Objection.

Planning Application number: 2025/62/91053/W

Change of use and alterations to barn to form three dwellings including associated works

Location: land off, Wood Lane, Colnebridge, Huddersfield, HD5 0PX.

GROUND FLOOR PLAN
1:50

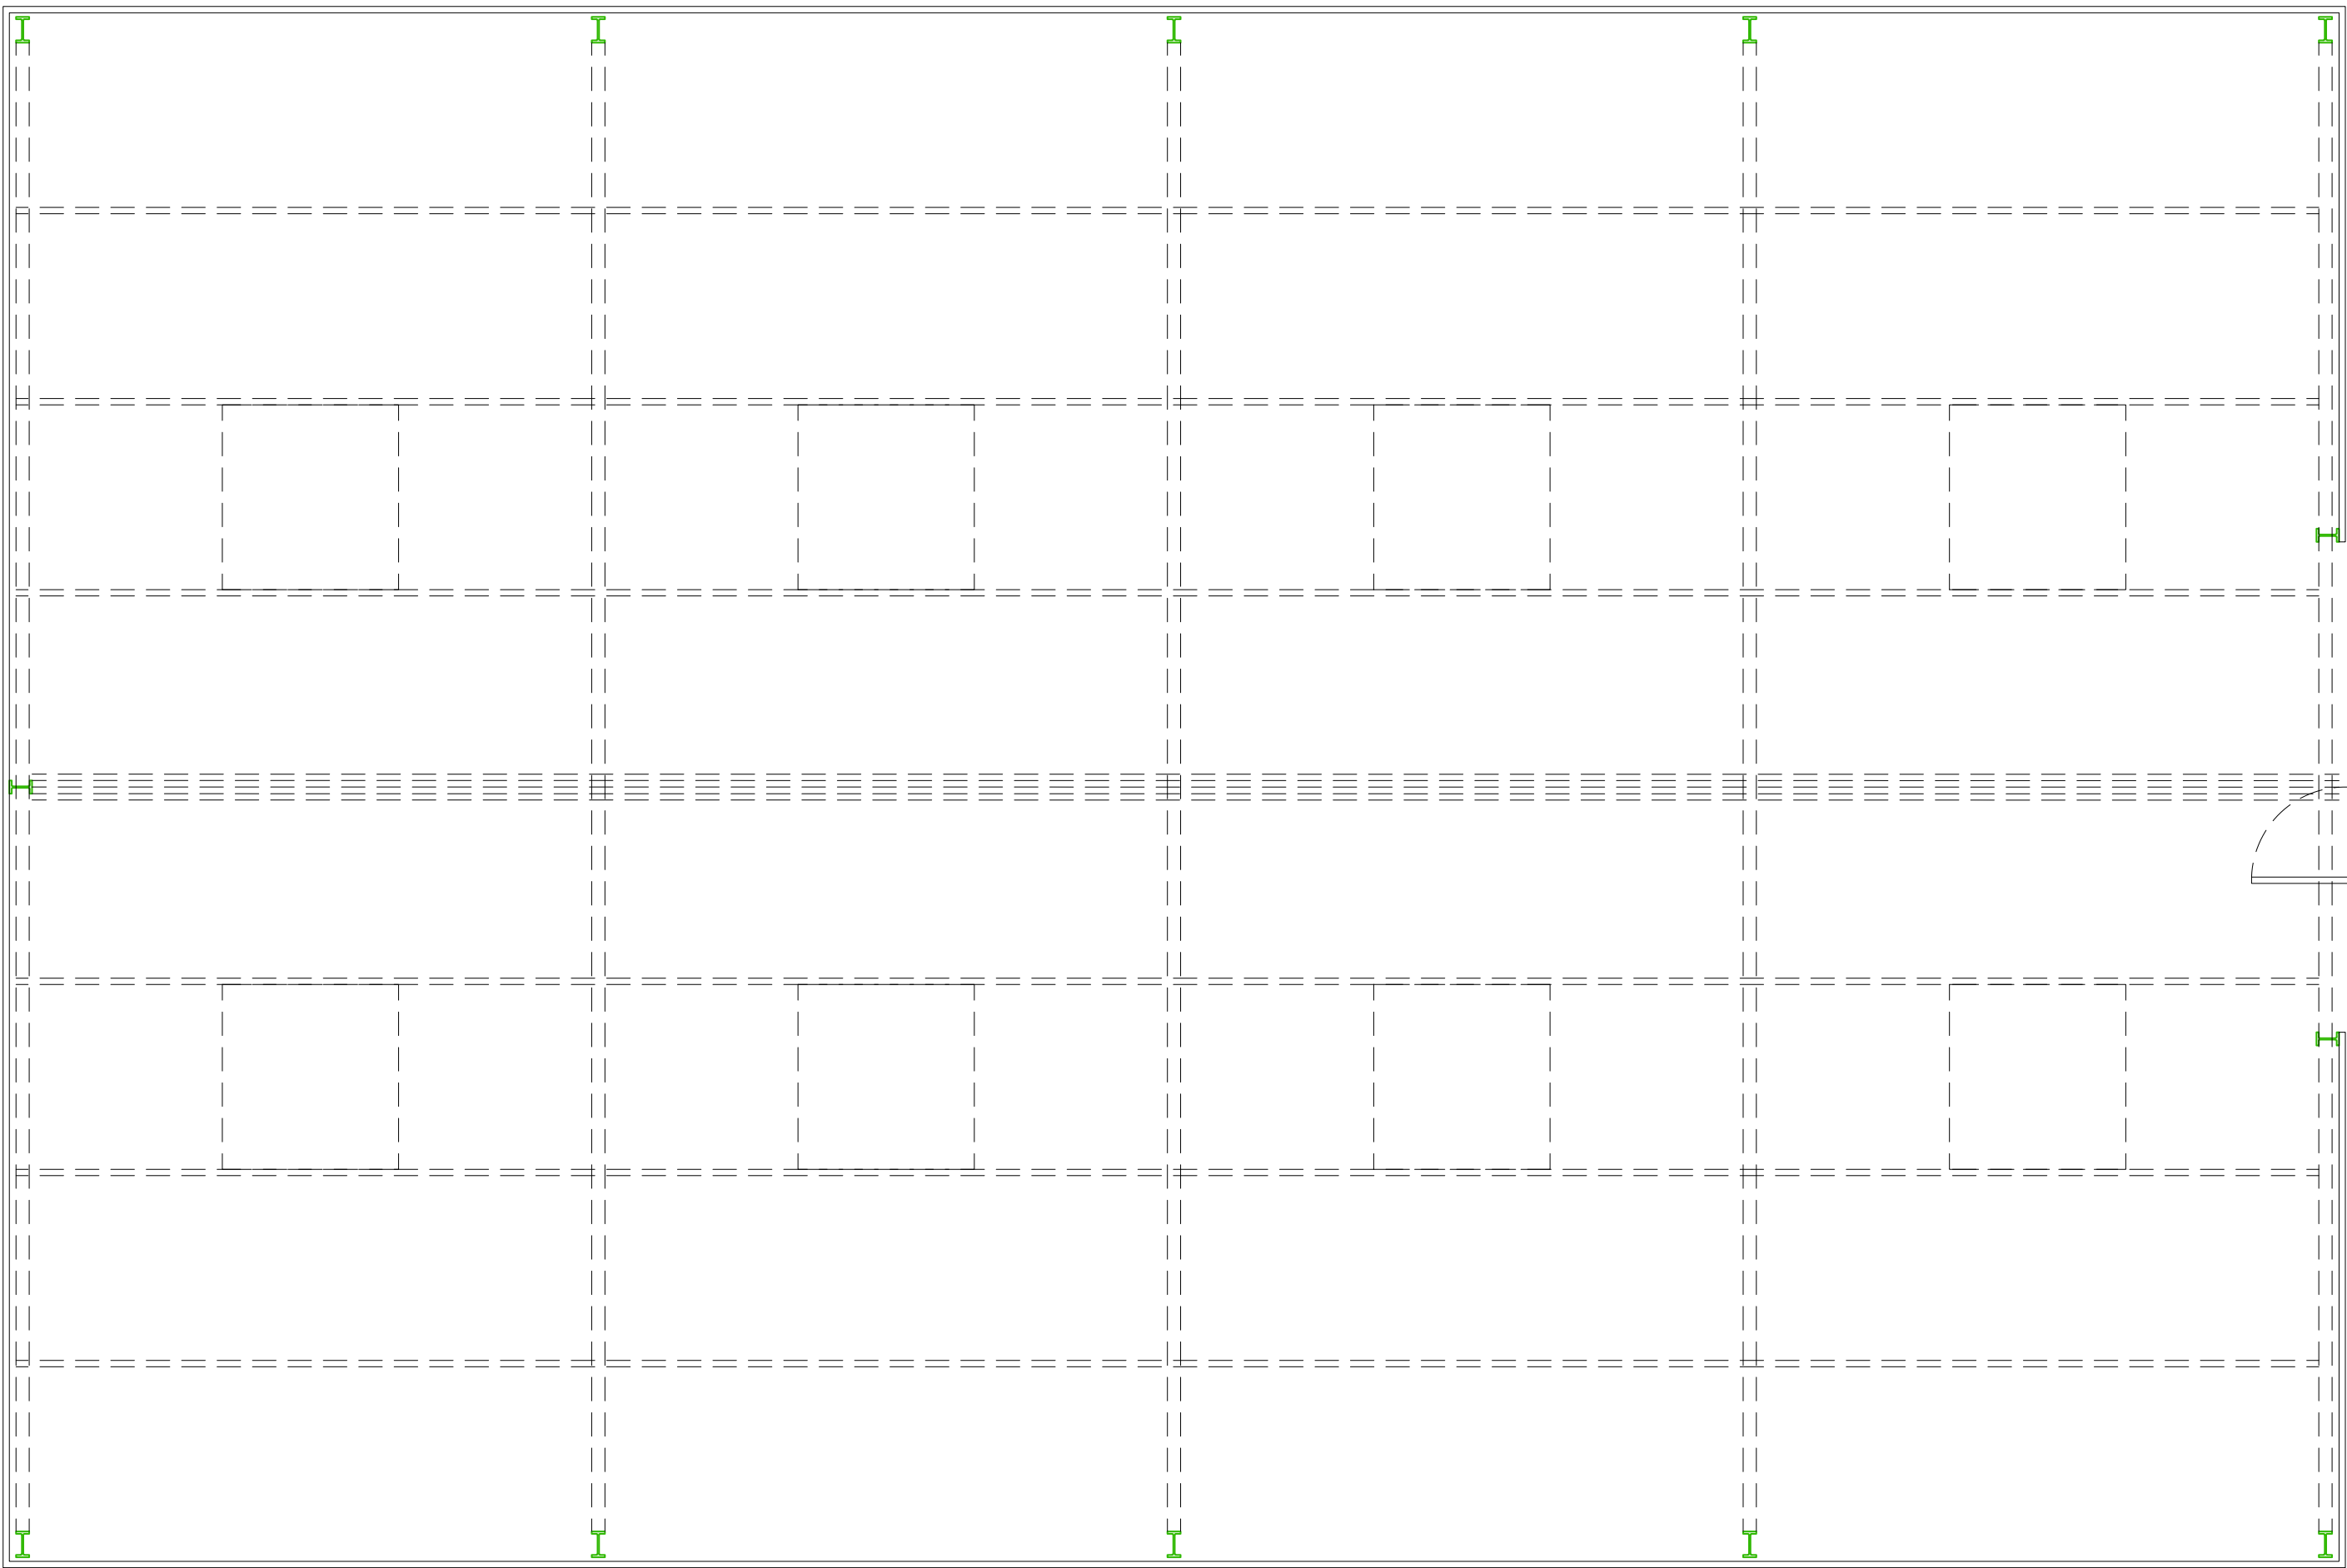
We note that Bridleway Kirkburton 251 will be directly impacted by this development

We seek further detail on the above development implications regarding the bridleway.

This development must not temporarily close or obstruct the Bridleway. We would ask, should planning permission be granted any damage caused to the surface of the bridleway must be repaired, reinstated in character with its surroundings, exactly as it was prior to any works taking place. Any improvements to the surface of a bridleway must be for the primary user, the horse. We ask that you consult with us regarding any surface material to be used. Tarmac is not one of our recommended surfaces.
